CITY OF PORTLAND

as permission to Change of Use to - Grocery & Day Spa

AT 0 DIAMOND COVE

Permit No: 05-0287	Issue Date: PERMIT ISSUED APR 21 2005	SBL: 083F A320001
-----------------------	--	----------------------

**1 FLOOR PLAN**  
SCALE: 1/4" = 1'-0"

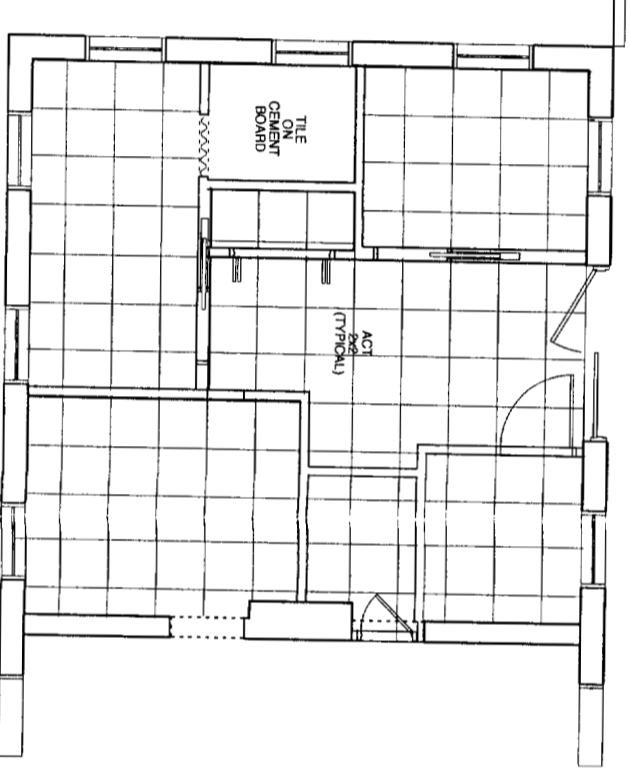
- 1) Design specs for the steel lintels must be submitted to this office
- 2) Separate permits are required for any electrical, plumbing, or heating.
- 3) Bathrooms must have mechanical ventilation or operable window
